TRAFFIC CONTROL PLAN
TWO ADDISON CIRCLE
3.371 ACRES
15600 DALLAS PARKWAY
TOWN OF ADDISON, DALLAS COUNTY TEXAS

DESIGN	DRAWN	DATE	SCALE	NOTES	FILE	NO.
JAK/KFW	KLH	AUG 2008	NTS			C5.3

DESIGN	DRAWN	DATE	SCALE	NOTES	FILE	NO.
JAK/KFW	KLH	AUG 2008	NTS			C5.3

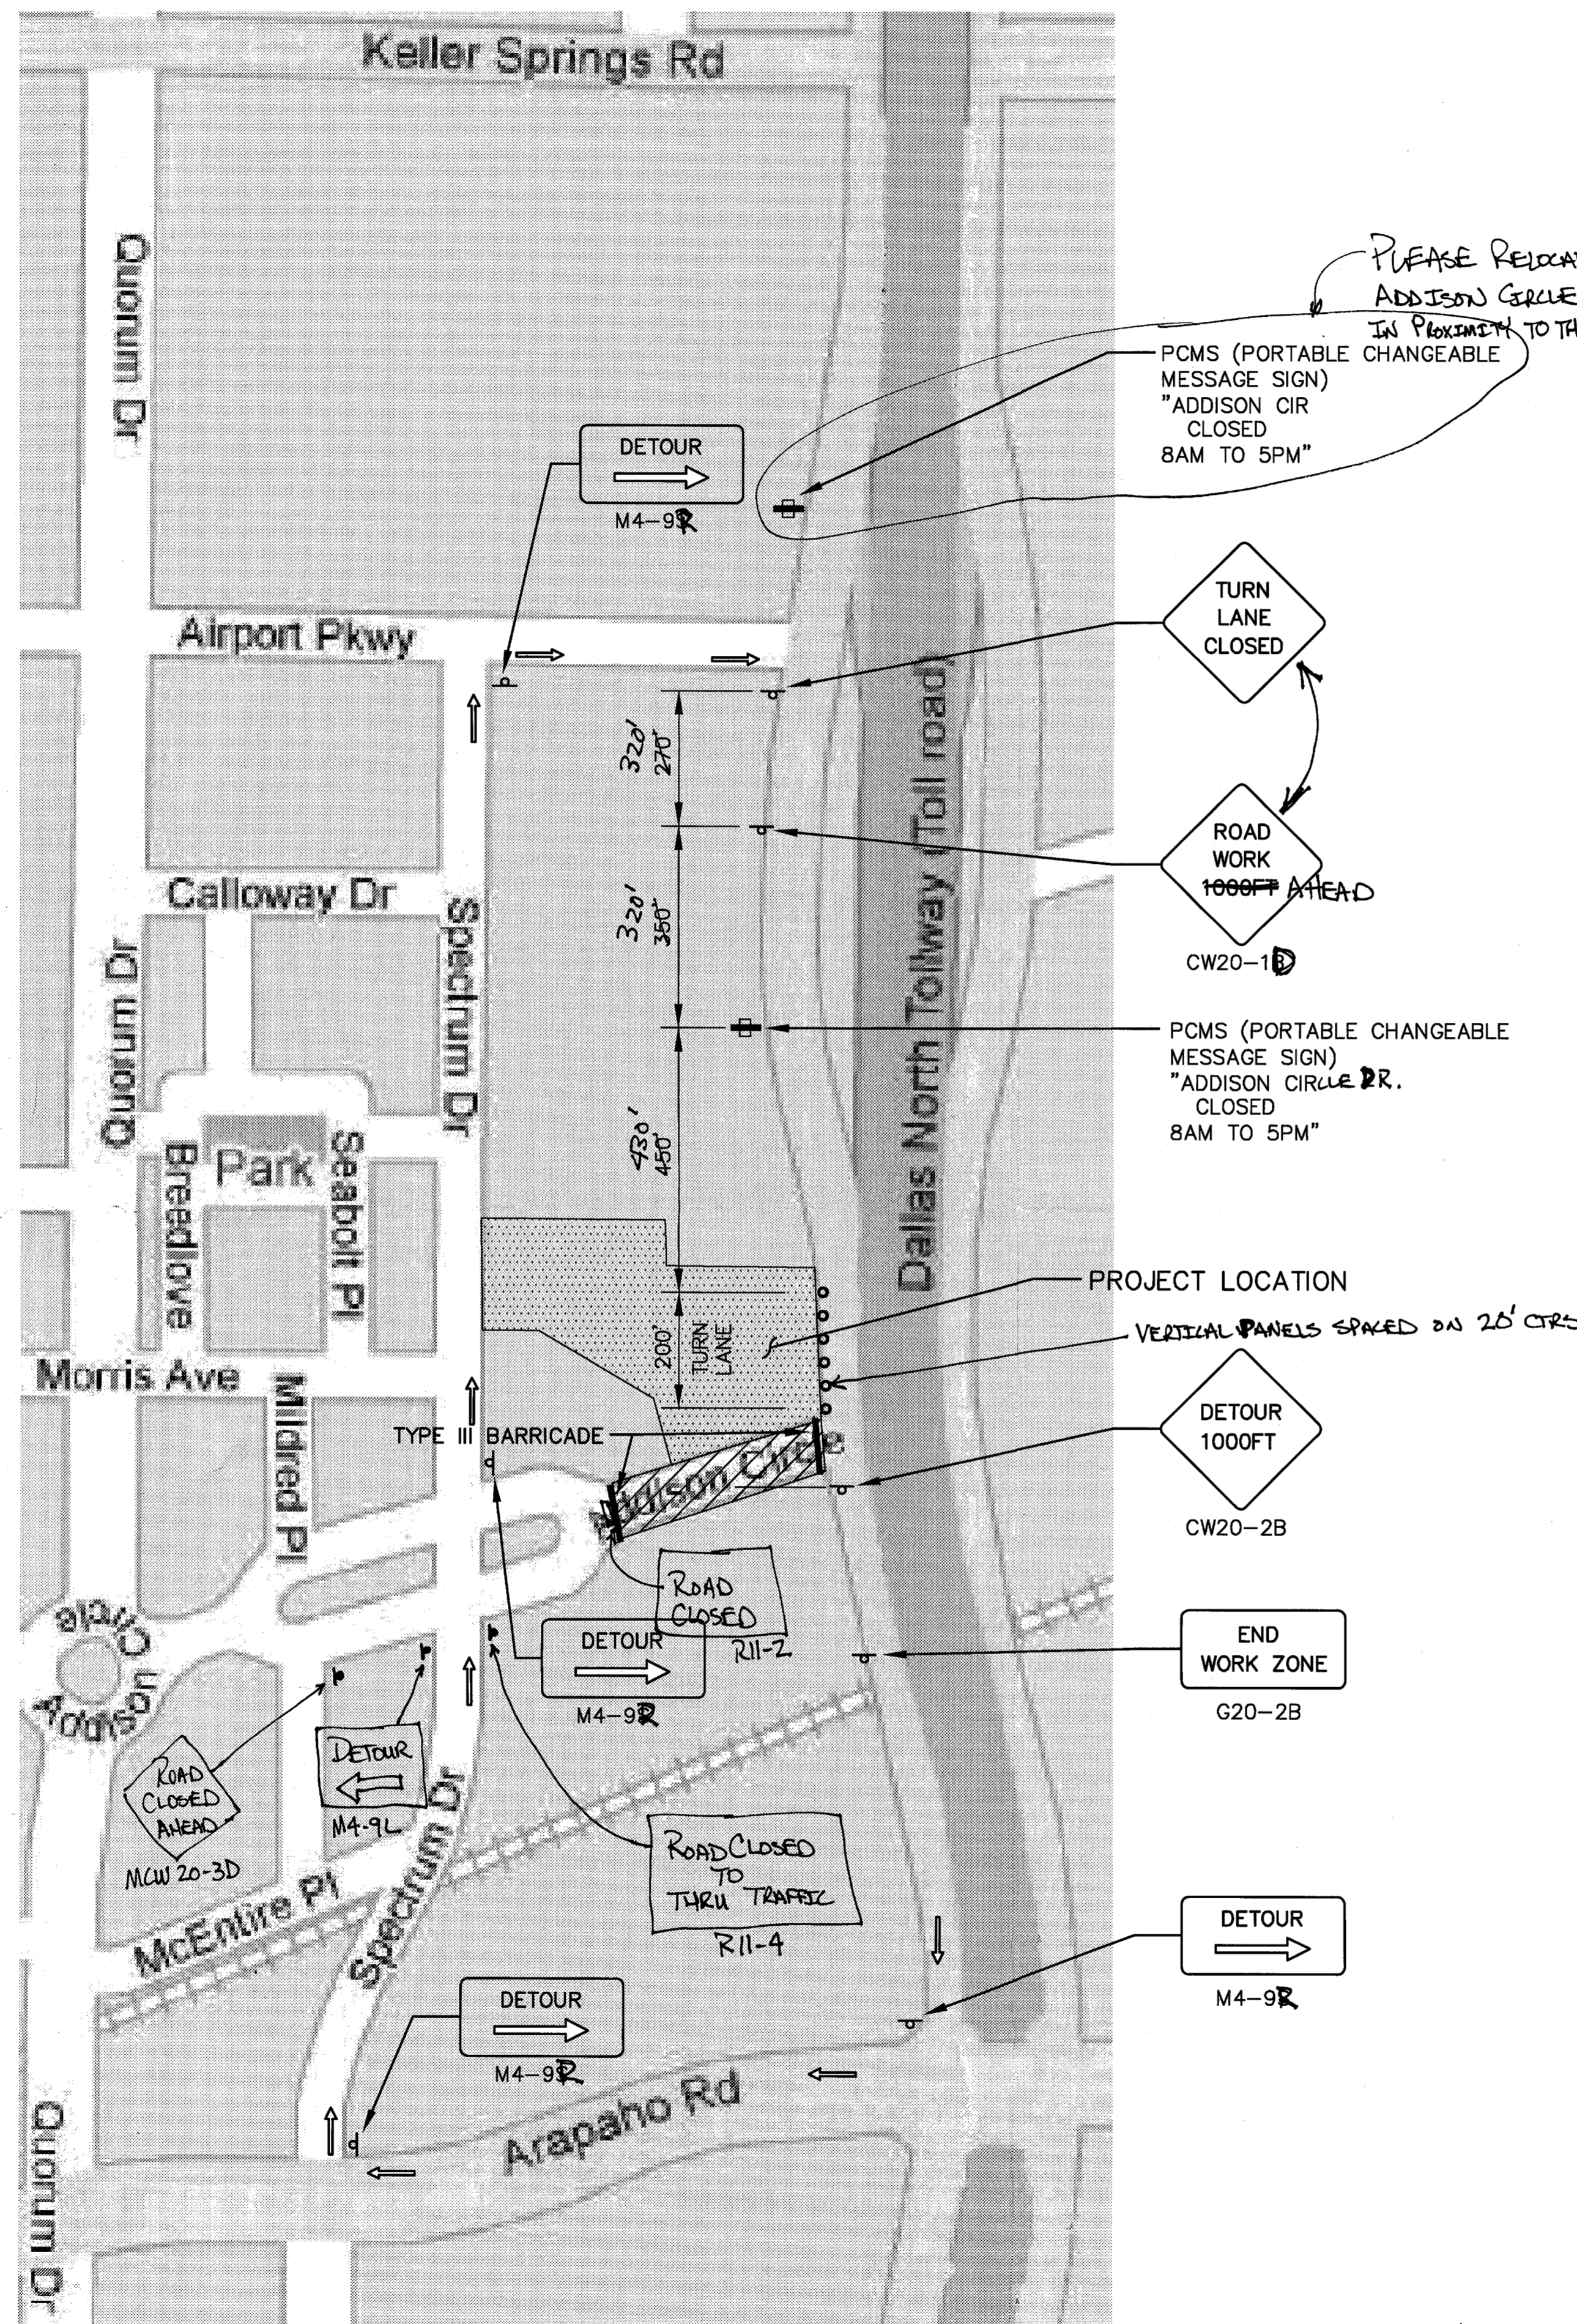
- This work cannot be done during Oktoberfest.
- Not by all businesses + residents affected. Coordinate with Post
- SIGN FOR ENTRANCE + DELIVERIES TO ADDISON CIRCLE OFFICE BUILDING AT THEIR SOUTH ENTRANCE.
